From: Chris Moore <[REDACTED]>
Sent: 08 June 2020 20:02
To: Maria Tomalova [REDACTED]
Subject: BE/40/20/PD

From: Maria Tomalova [REDACTED]
Sent: 08 June 2020 15:08
To: Chris Moore <[REDACTED]>
Subject: BE/40/20/PD

In order to make a better assessment of the potential for noise disturbance please could the applicant provide details of the location of the current extract system for the takeaway business in relation to the proposed domestic dwelling and more details on what the workshop is used for – is it part of a business or residential workshop, what hours does it operate and what is it used for?

PROPOSED GROUND FLOOR PLAN

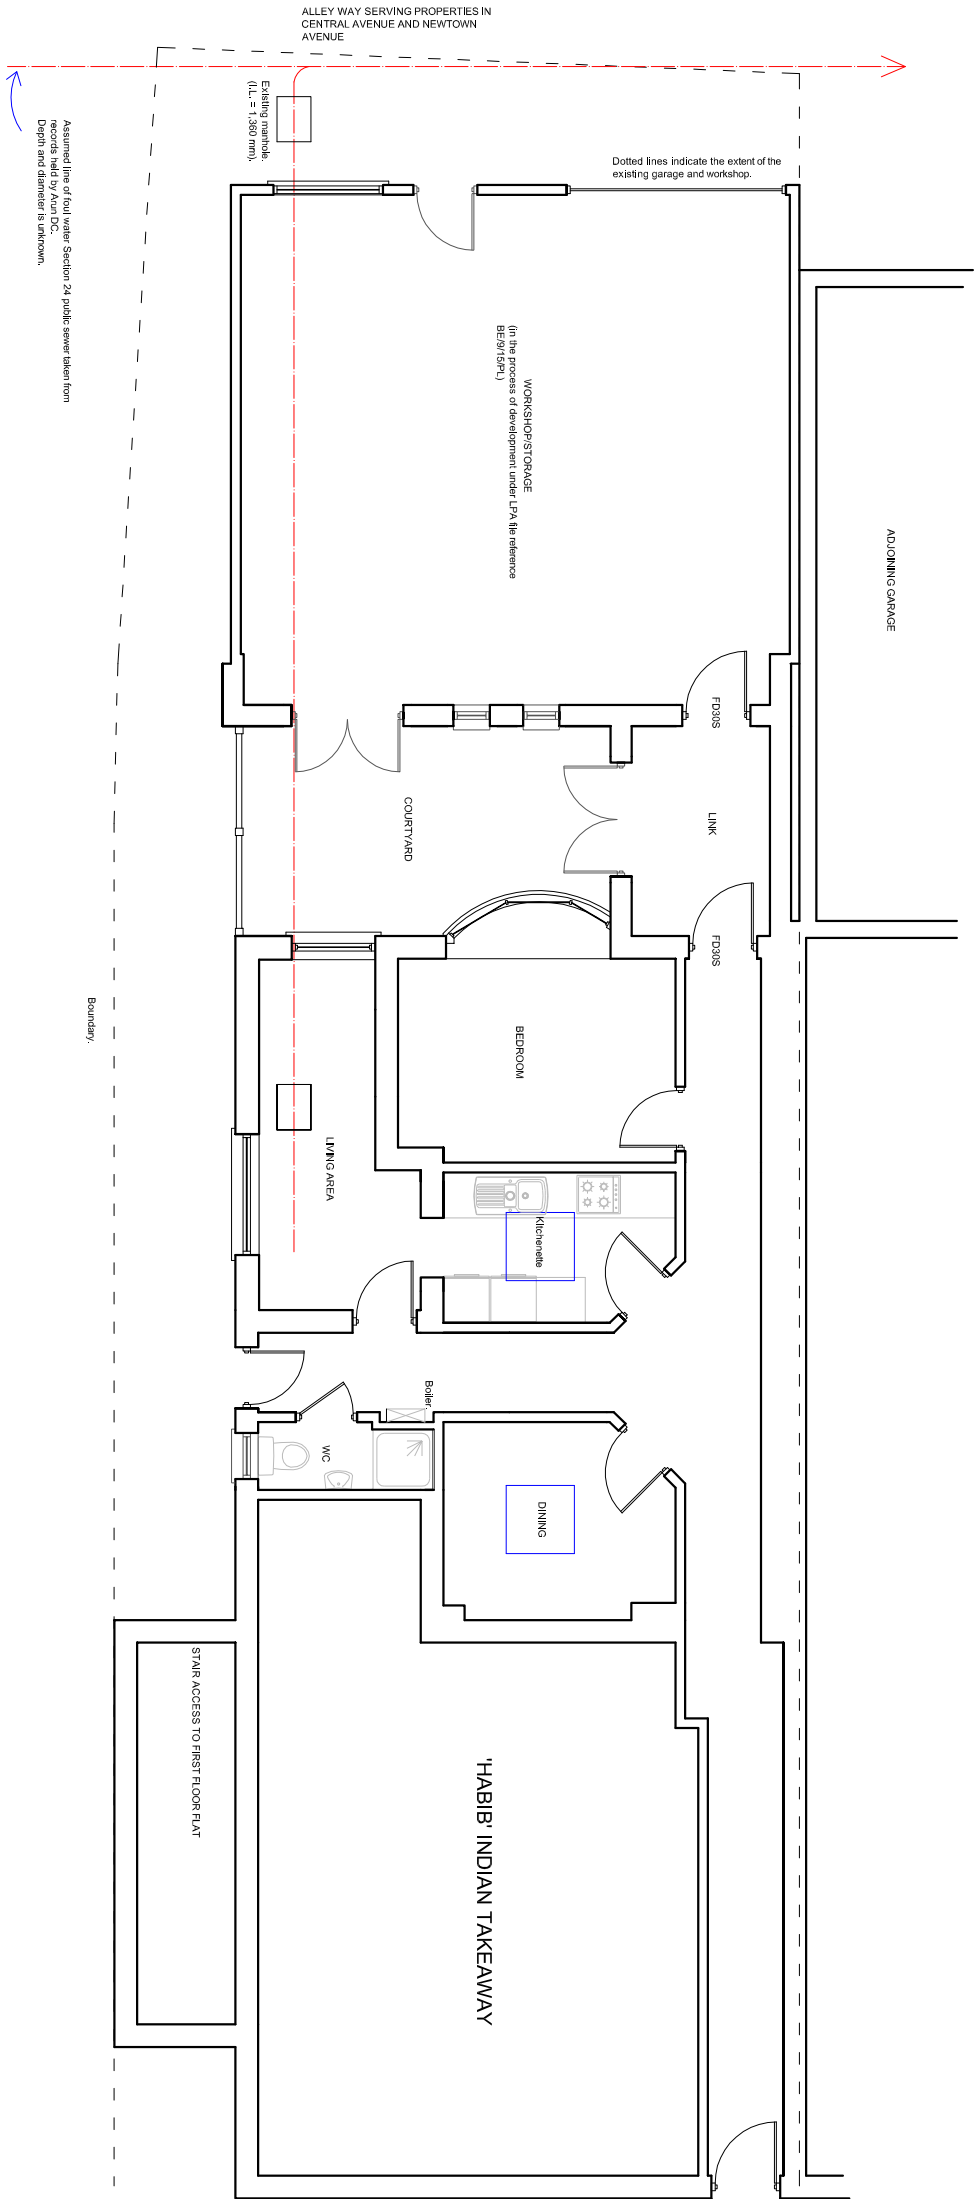
The applicant states that there is ample sound insulation between the proposed dwelling and takeaway business, if the applicant has any documents or proof of this I would be interested to see them.

3. The existing takeaway use is separated from the offices with cavity construction (the thicker wall shown on plan) which is two skins of concrete blockwork with render finish either side forming a 50 mm cavity. The thinner wall shown is a single skin (100 mm) of blockwork with render either side which would be proposed to be upgraded with 2 x layers of 15 mm 'Gyproc SoundBloc' sound insulating plasterboard fixed to resilient bars in turn fixed to the existing solid wall with dense mineral fibre infill – in accordance with the Building Regulations. It is also worth noting that the rear portion of the take-away that abuts the proposed shower area is currently used for storage – the kitchen and prep area is sited towards the centre of their part of the building.

4. My client has no evidence to the existing separating construction I am afraid, however, the conversion works will need to be the subject of a 'change of use' application under the Building Regulations and will as such need to comply with 'Approved Document E' in relation to satisfactory sound insulation provision between the units. Pre-completion sound testing will need to be undertaken to justify this as and where directed by Building Control.
